To: Mr. Pete Van Grootheest, Senior Project Manager (BBS Construction)
From: William Sherwin, P. Eng (MP) Thomas Gryze, M.A.Sc., P.Eng. (MP)
Date: May 3, 2024
Re: 1540/1560 Star Top Road Warehousing Development – Road Safety Review

**Re: Redevelopment of 1540 & 1560 Star Top Road, Boone Plumbing & Heating Supply Inc.
Proposed New Warehouse
Preconsultation Feedback Response Submission No. 1
City File No. PC2023-0219**

**Landscape Plan**  
 Scale: 1:400  
**L1**  
 DWG # 19125

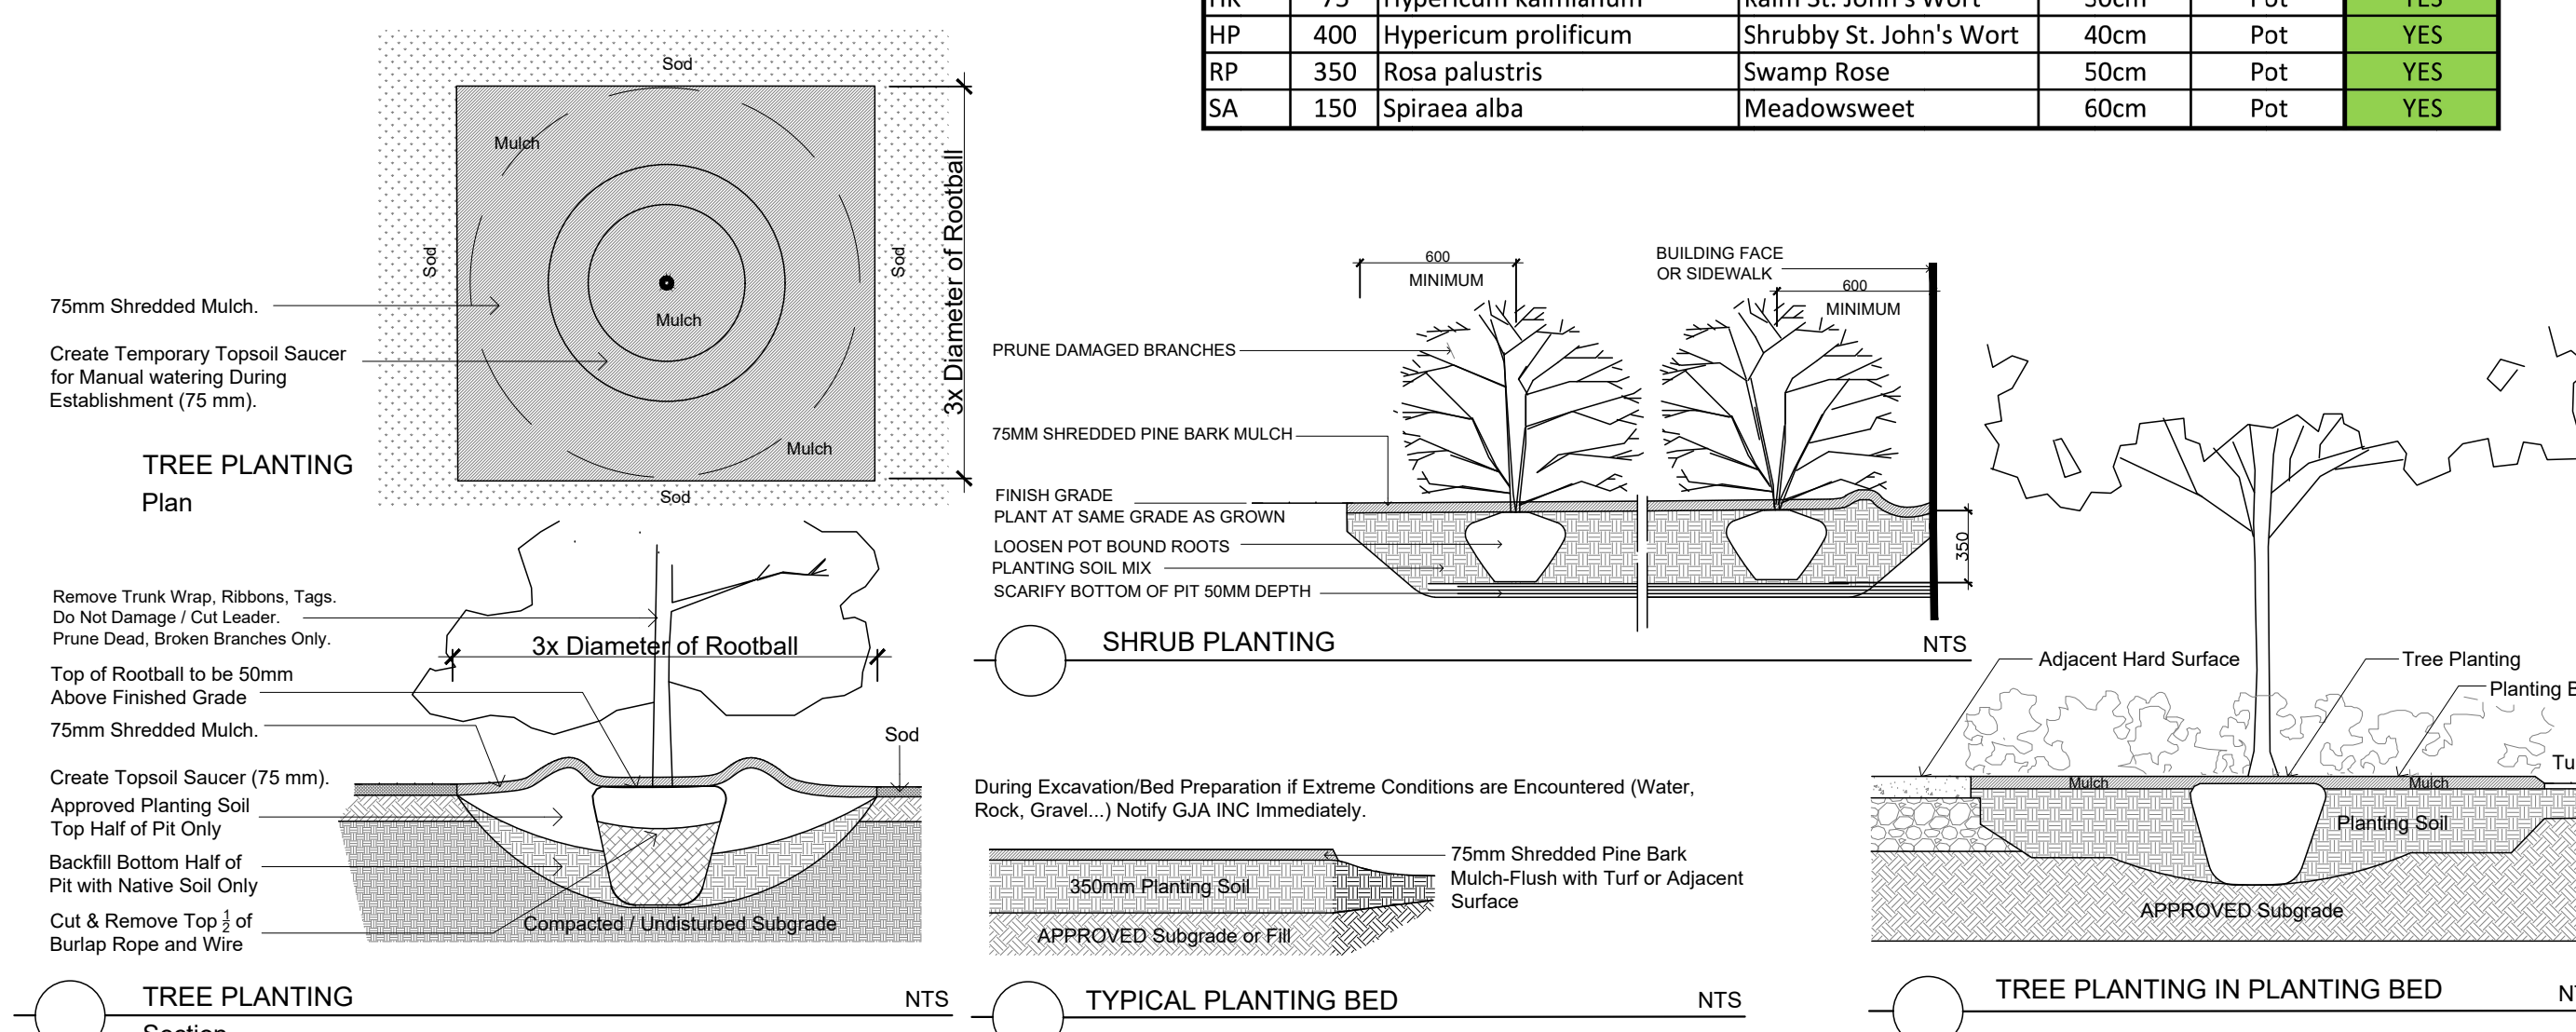
1. Landscape Plan:
 - a. General Plan Elements:
 - i. Missing name of civil consultant and surveyor.
 - ii. Missing key plan.
 - iii. Missing property boundary/property line.
 - iv. Missing legal description.

**01 PROPOSED SITE PLAN**  
SP-A01 SCALE: 1:500

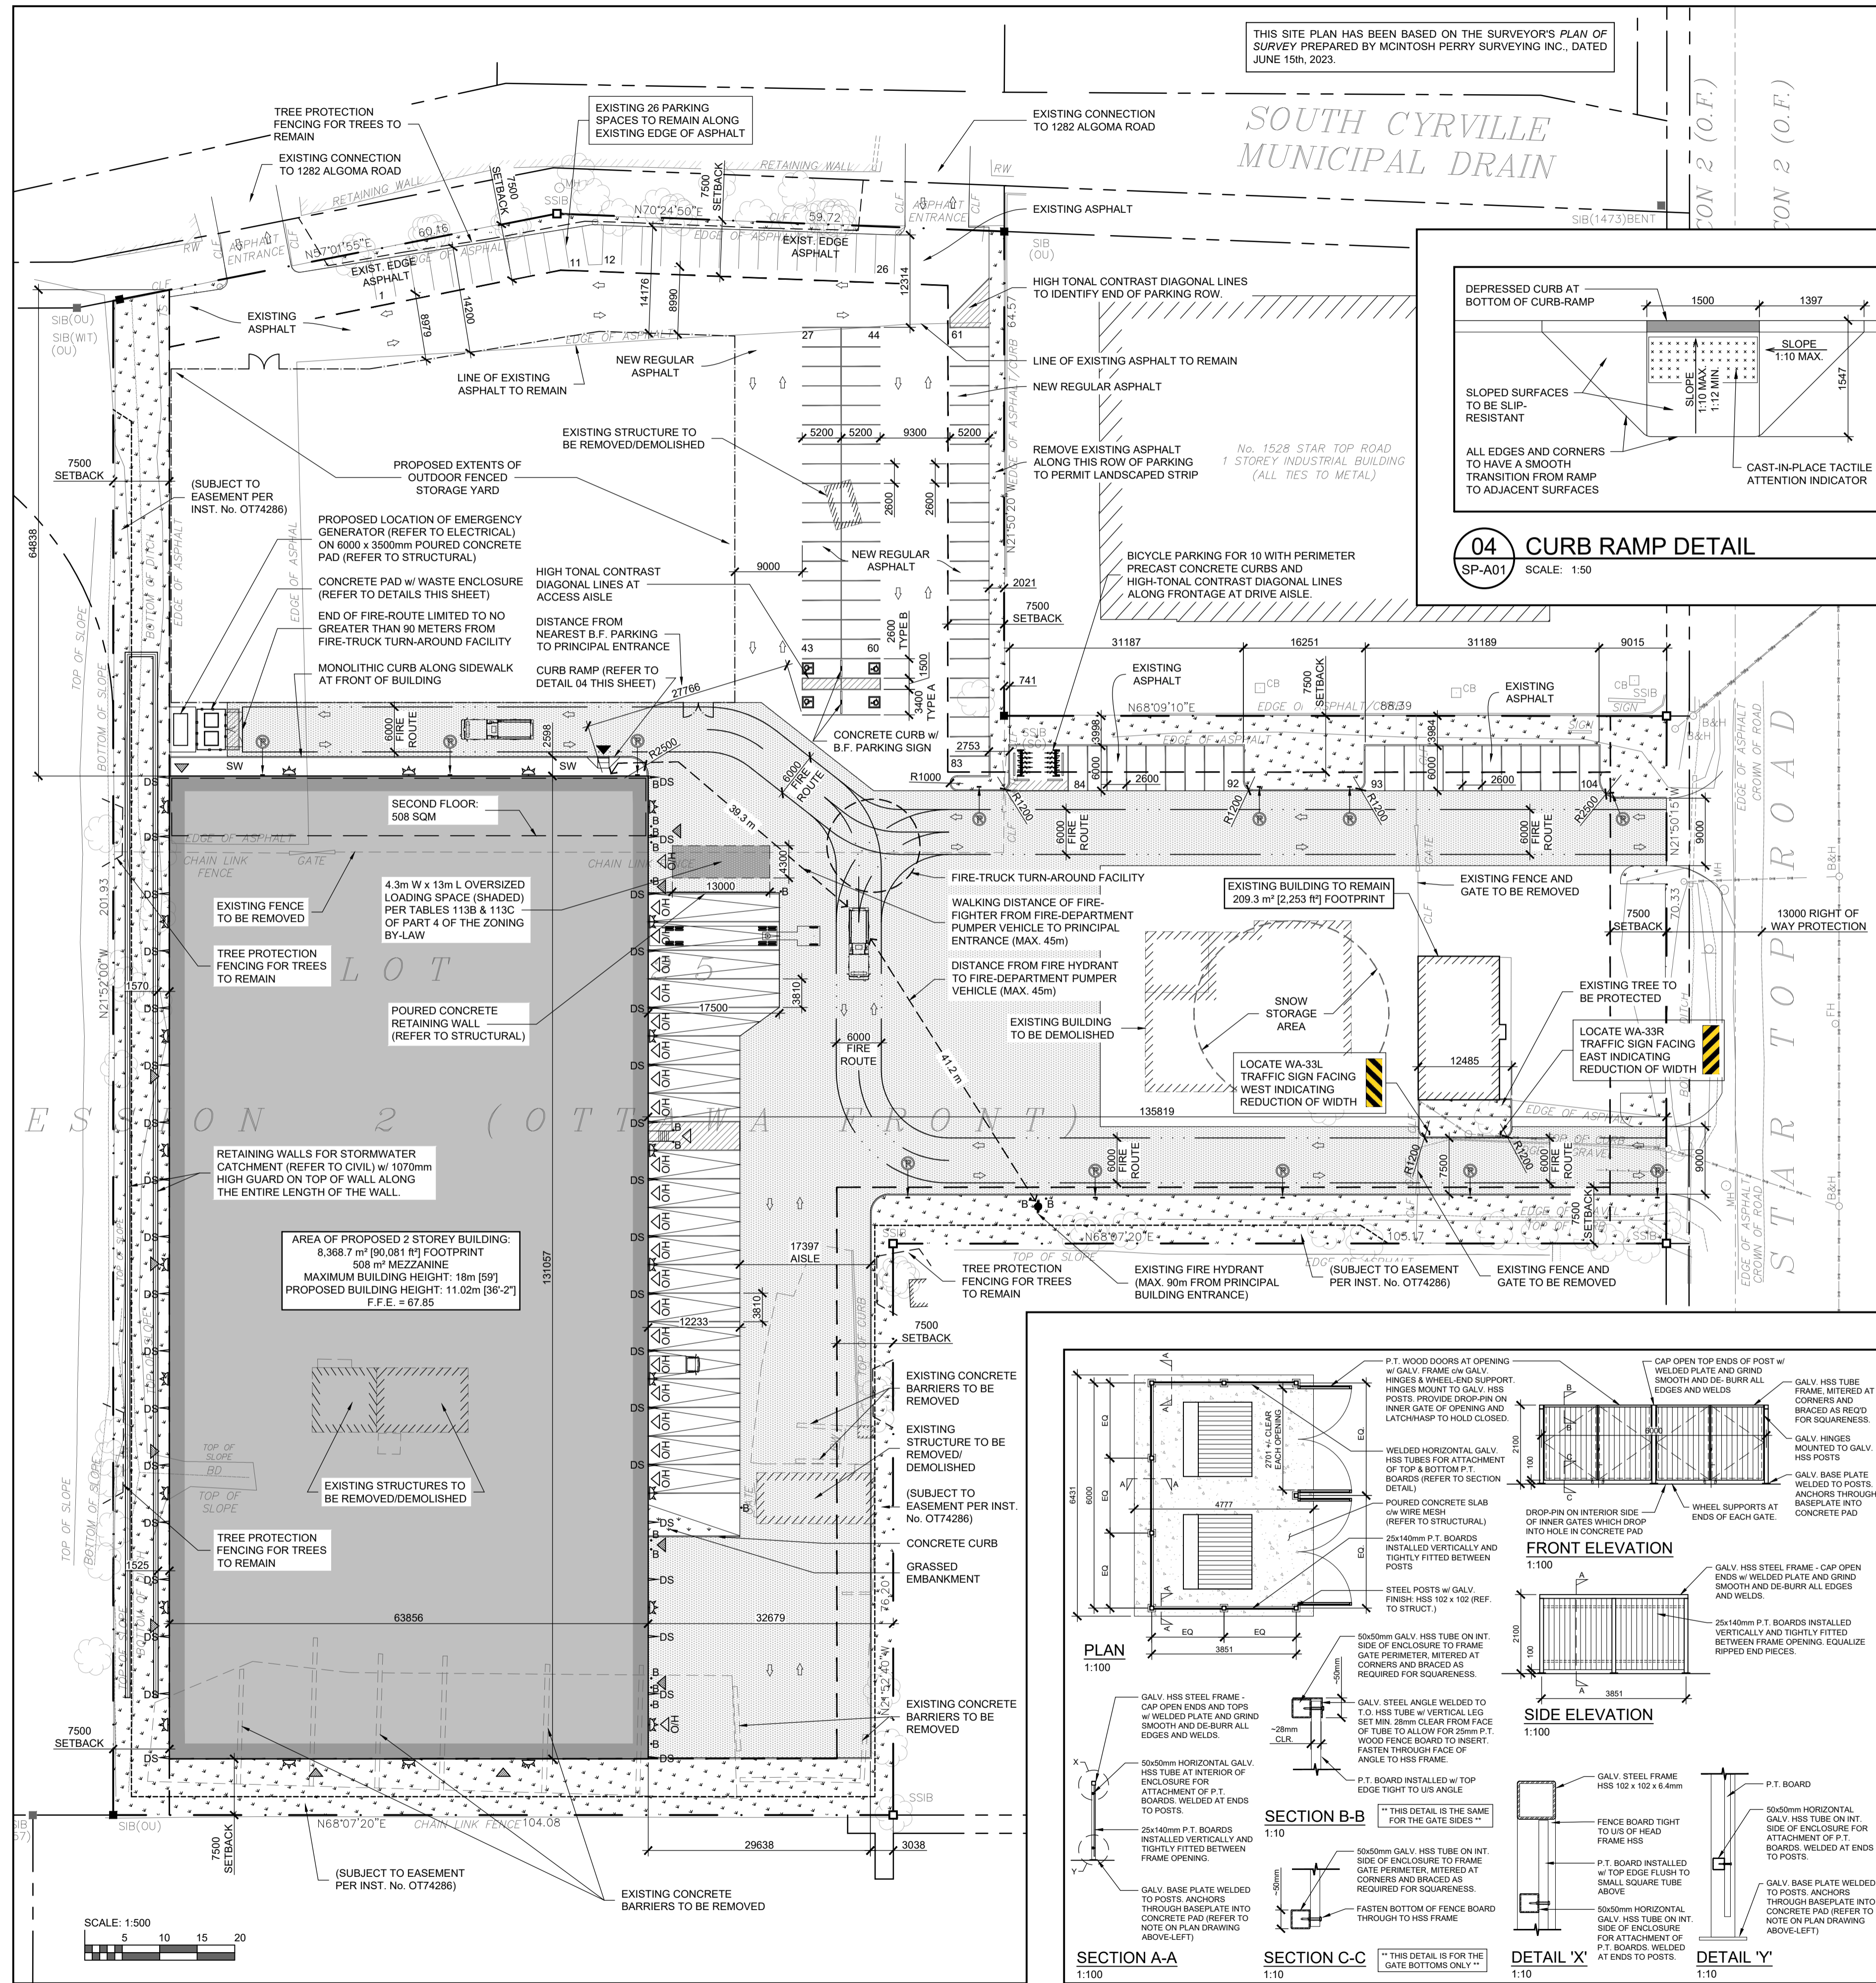
1. The Zoning By-law Checklist has identified deficiencies with the current proposal:
 - a. Please ensure that any proposed sales or display area comply with the provisions of 203(4).
 - b. The IL prohibits outdoor storage as per 203(5) while a large outdoor storage area is being proposed.

2. Confirm if curbs are being added along the frontage. Bus stop upgrade may be required if the frontage is urbanized.

3. If not urbanized, recommend adding curb returns to better define the accesses.

4. Confirm that the fire truck turning movement does not conflict with the existing curb close to the southerly access (Drawing C-3).

REPLY: The proposed outdoor storage area has been removed from the Site Plan at this time.

REPLY: The frontage will not be urbanized, nor are curbs proposed.

REPLY: Please see above.

REPLY: The existing curb close to the southerly access is proposed to be removed.
